Our reference: ECM: 8590436
Contact: Kathryn Sprang
Telephone: 4732 7834

28 March 2019

**Notice of Exhibition - Jordan Springs Public School (SSD 9354) at
14 – 28 Cullen Avenue, Jordan Springs**

Figure 3: MUSIC model layout

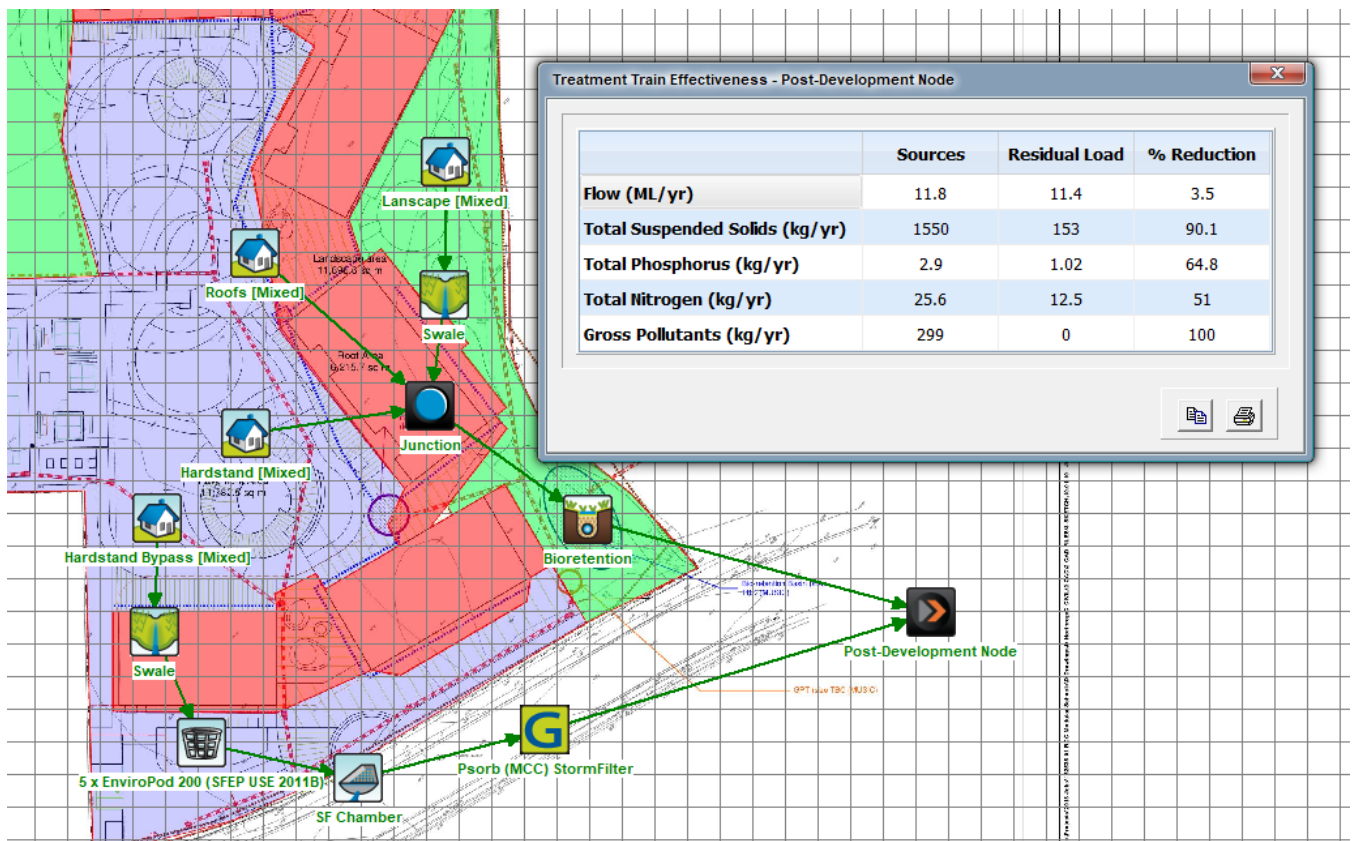
No electronic MUSIC modelling file (i.e. *.sqz file) was available for review. As such the proposed treatment could not be fully assessed. In addition, cross section details for the proposed Stormfilter device, including details of the size/type and number of Stormfilter cartridges must be provided on the Civil Works Plans. Details must correspond with what is in the MUSIC modelling.
